Accessibility Review Report – SSDA

Project Title: Mixed-Use Residential Development
40 The Retreat, Bringelly

Job Number: 23362

Date: 08 May 2024

DA1003
E

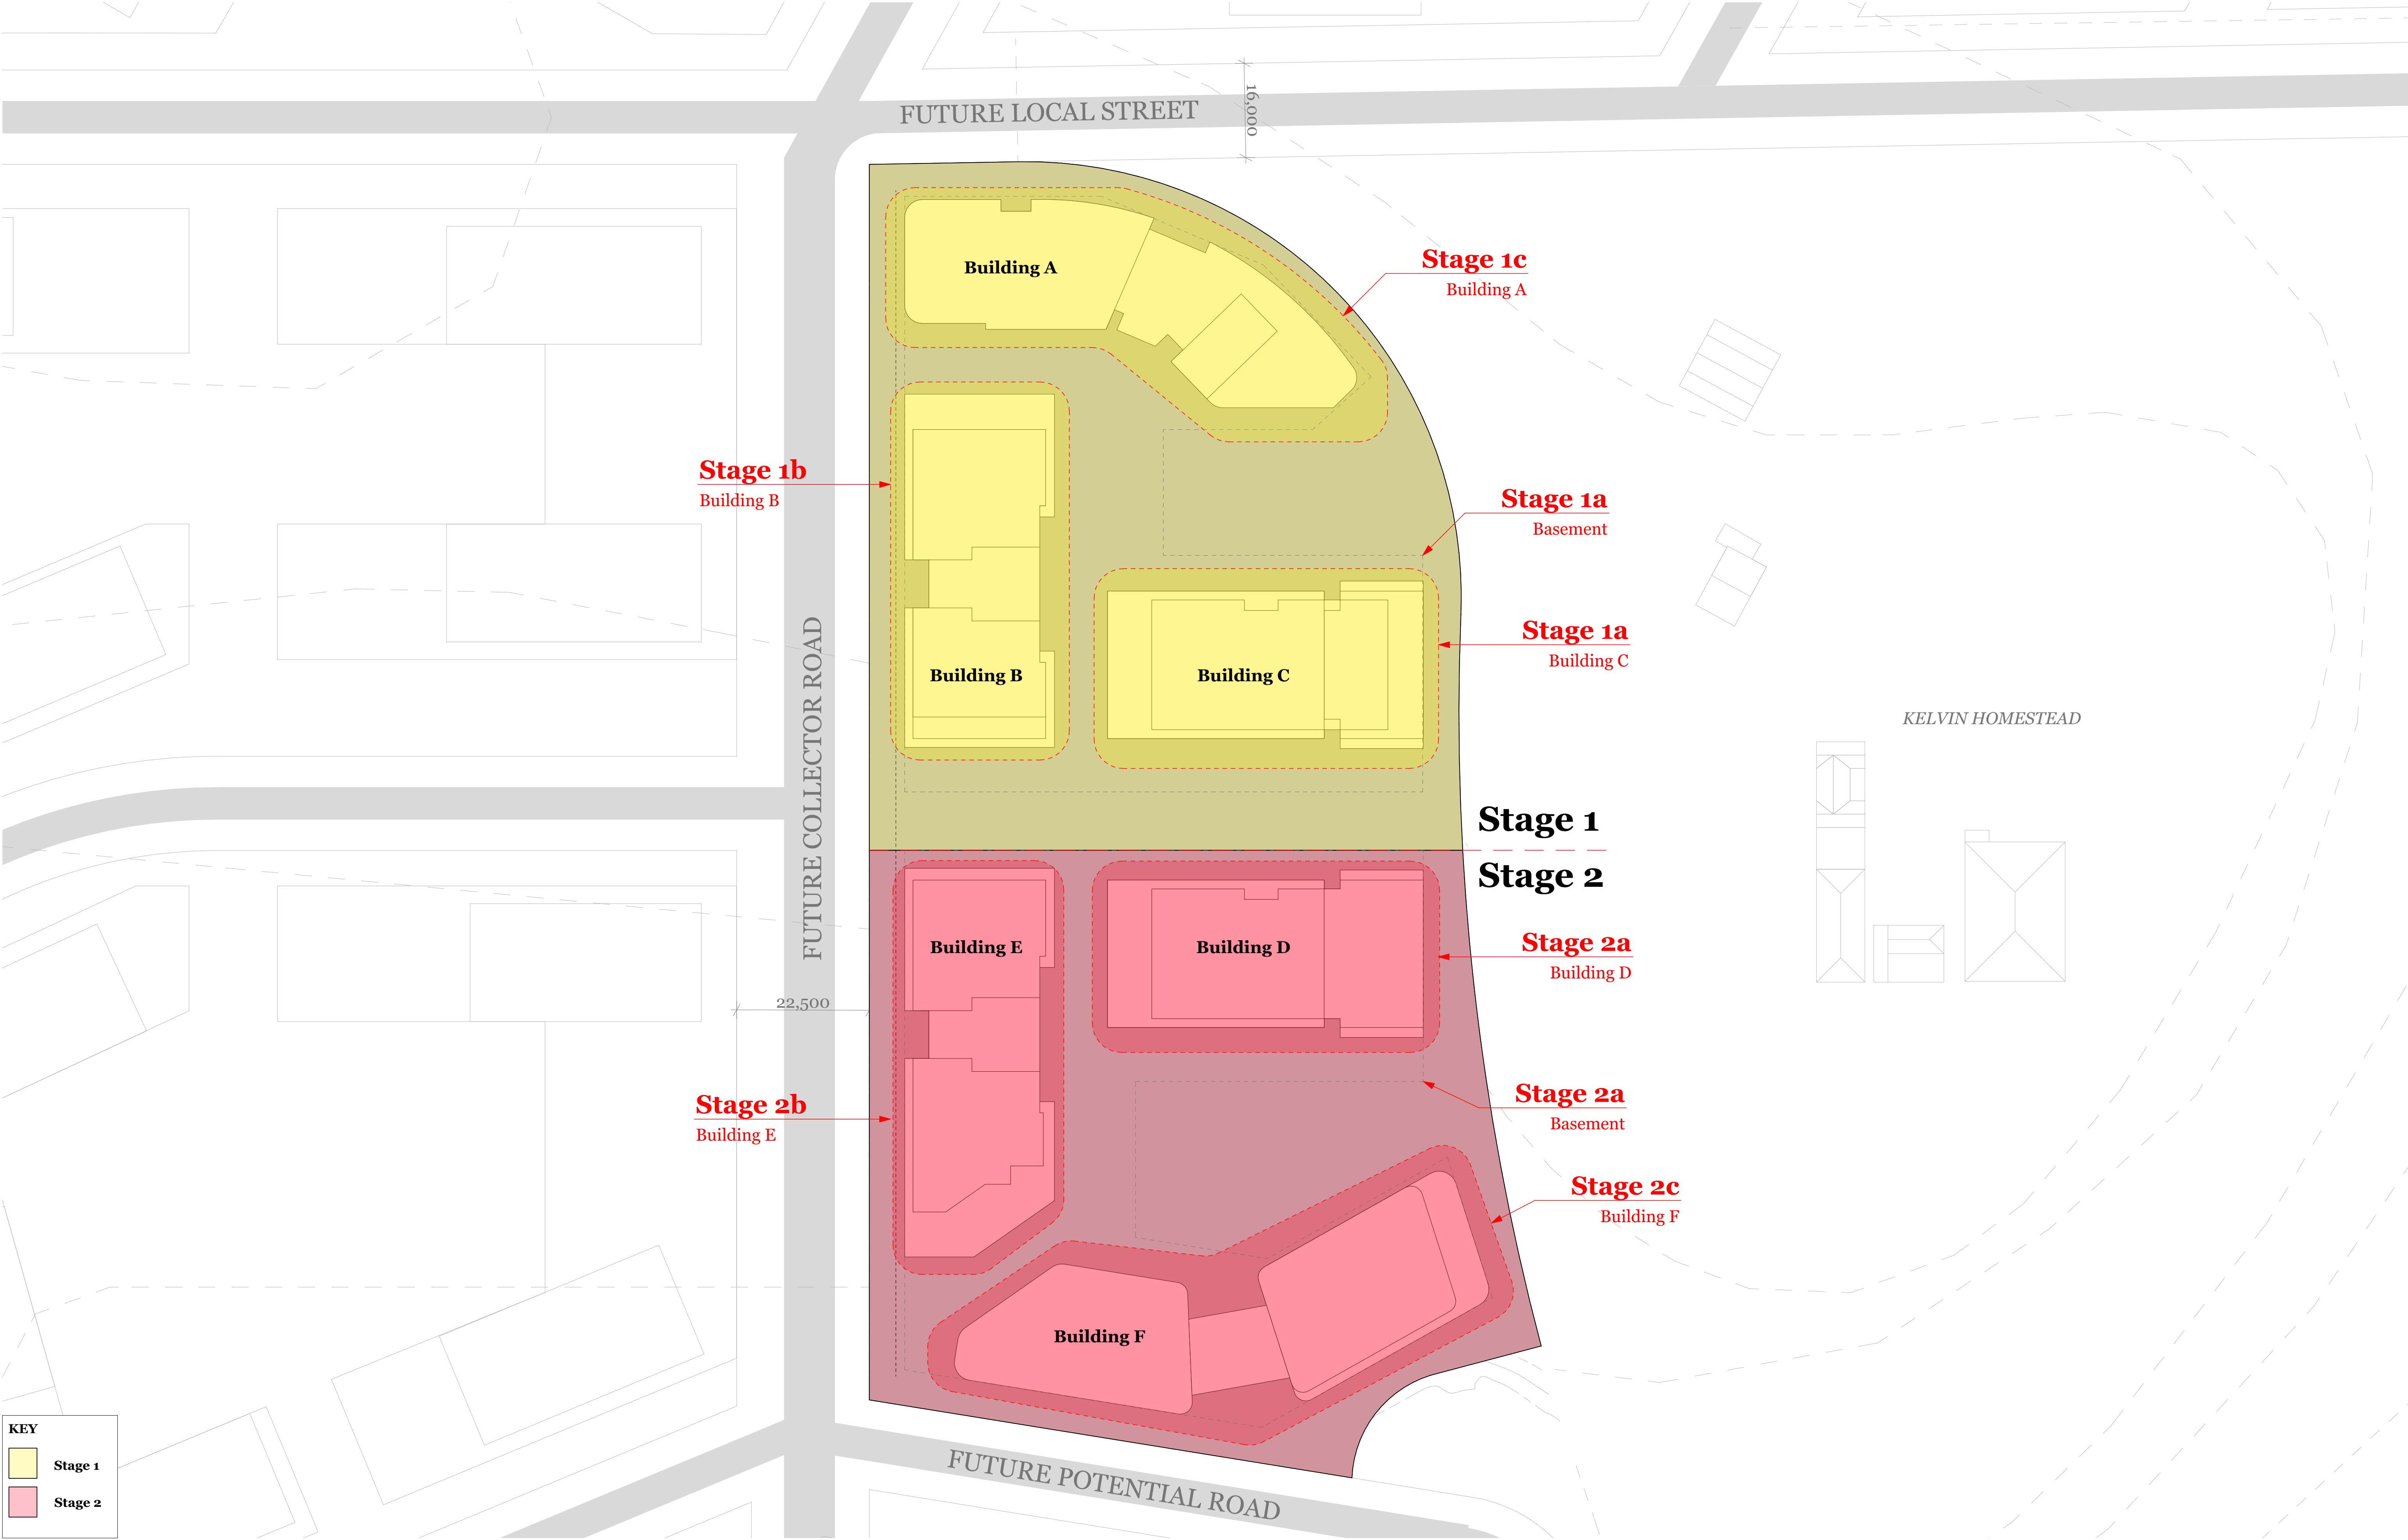
The allotment boundary to the site is indicated as having crossfalls at each façade off the future proposed roads.

Falls and gradients are identified at each of the pedestrian entrances with grades shown as not being steeper than 1:40.

Further review of external entrances from the allotment boundary will occur at detail design stage.

pedestrian entrances from the allotment boundary, a crossfall exceeds 1:40 based on RL's provided.

- Ensure kerb ramps comply with AS1428.1-2009 and sufficient landing space is provided at the top and bottom of the ramp.
- Stairways and ramps are to comply with AS1428.1-2009 (refer to clause D3.3 below).
- Stage 1: External Ramp between Buildings B & C
A 1:14 graded switch back ramp is proposed. The ramp is readily capable of complying with the requirements of AS1428.1-2009.
Further review of the ramp will occur at detail design stage.

DA2001
E

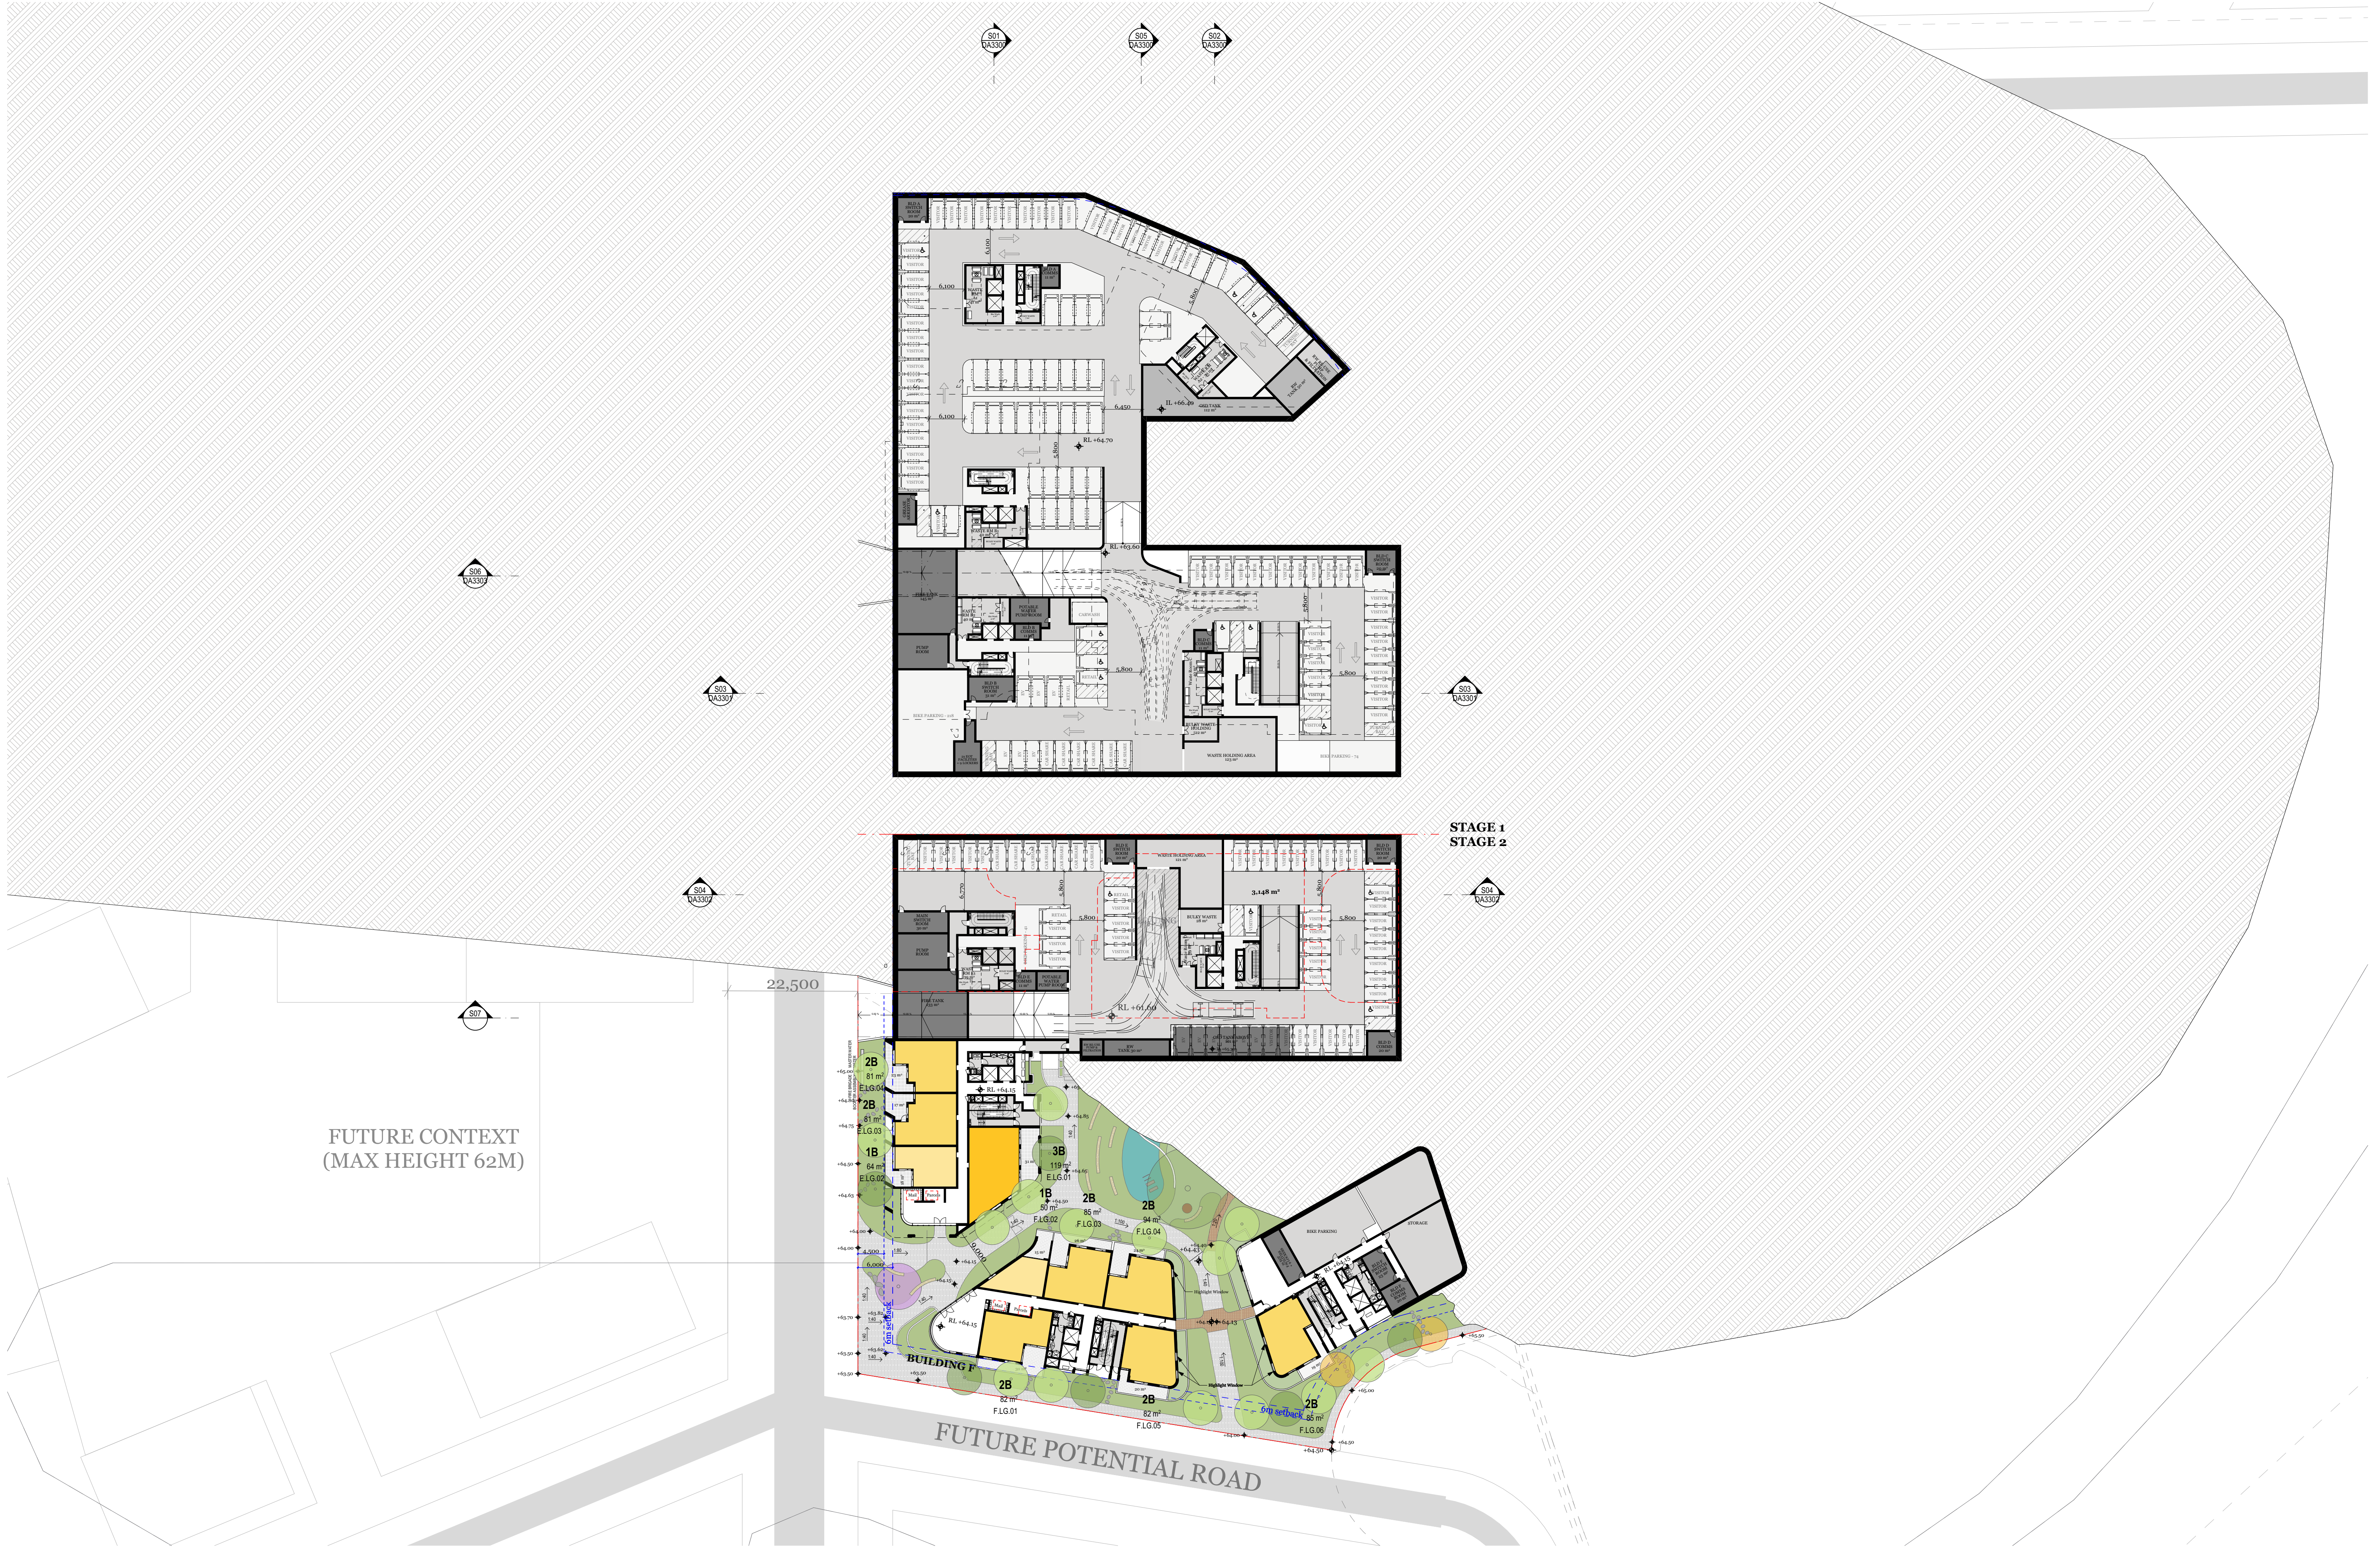
Accessible Parking

Accessible parking spaces are proposed within basement areas of the development.
Multiple passenger lifts are provided providing access between accessible parking spaces and buildings.
